CITY OF PORTLAND

Re: Porter Drywall Building #3 at 655 Riverside Street

On April 17, 2001 the Portland Planning Authority granted minor site plan approval with the following condition for the construction of Building #3 at 655 Riverside Street.

PORTER DRYWALL
DRAINAGE IMPROVEMENTS
WITH INFILTRATION TRENCH
 DATE: 4/13/01
 SCALE: 1" = 20'

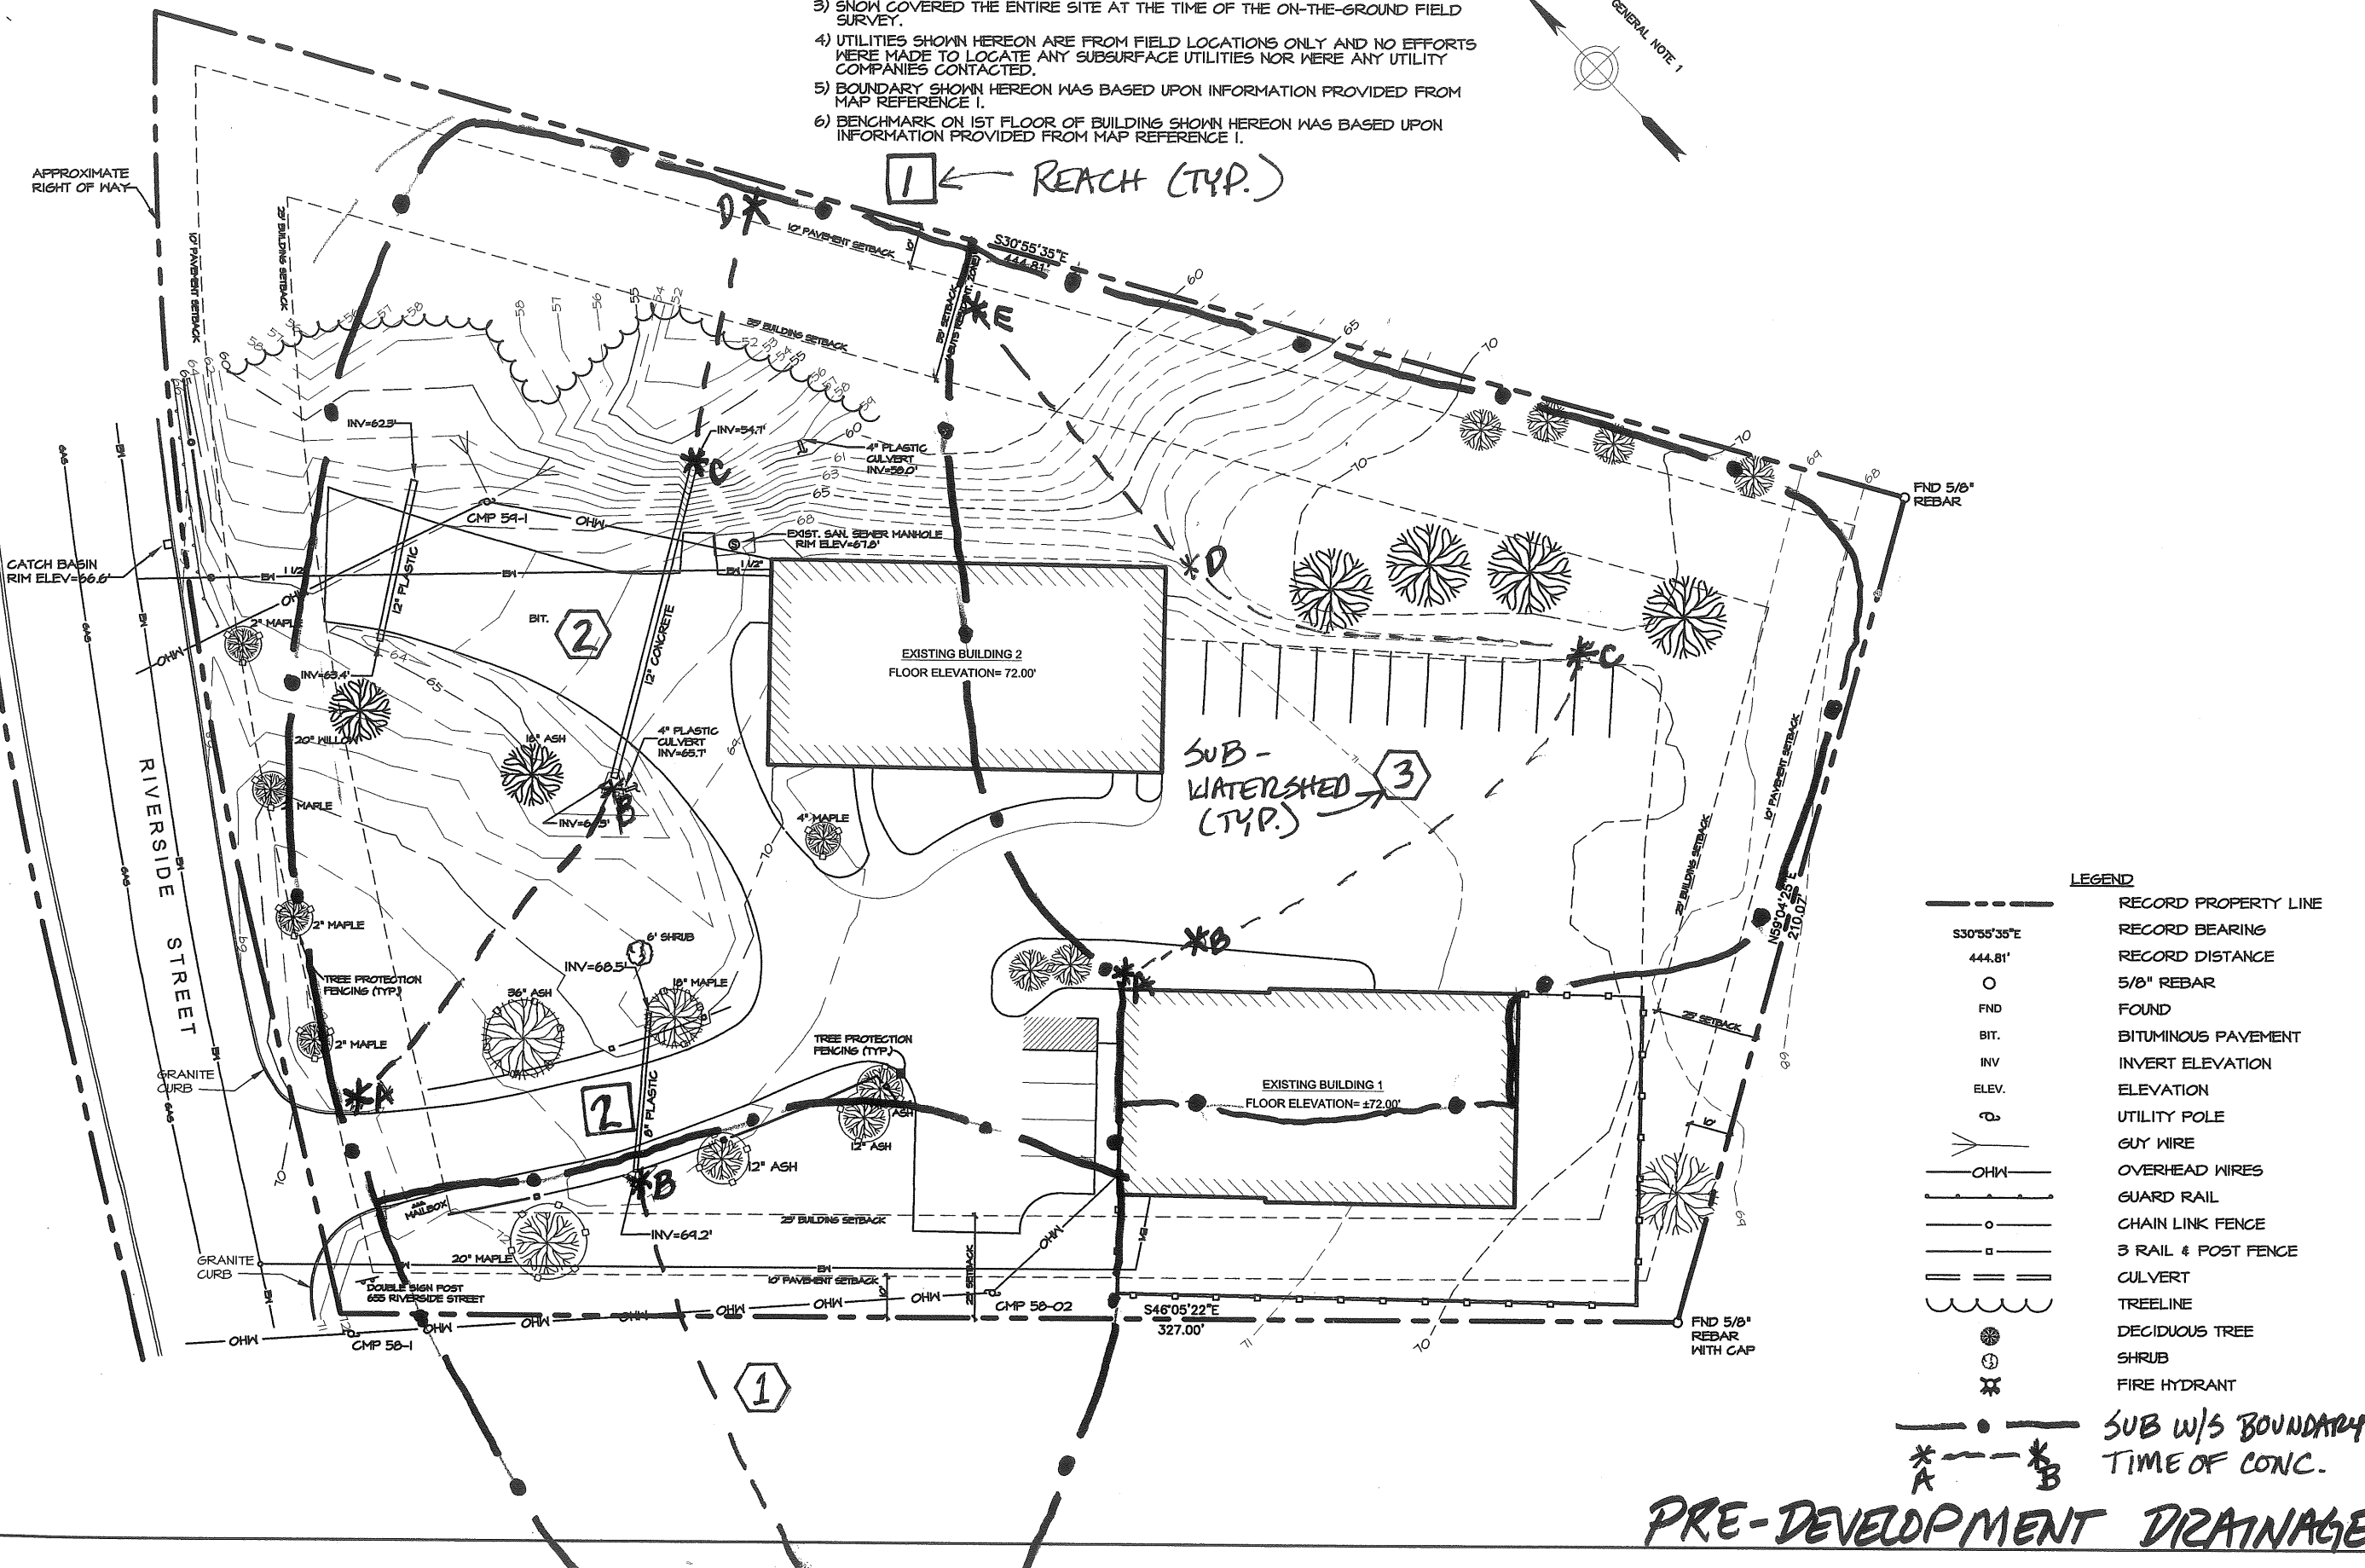
1. The applicant will submit an acceptable detail for the proposed infiltration trench prior to permit issuance.
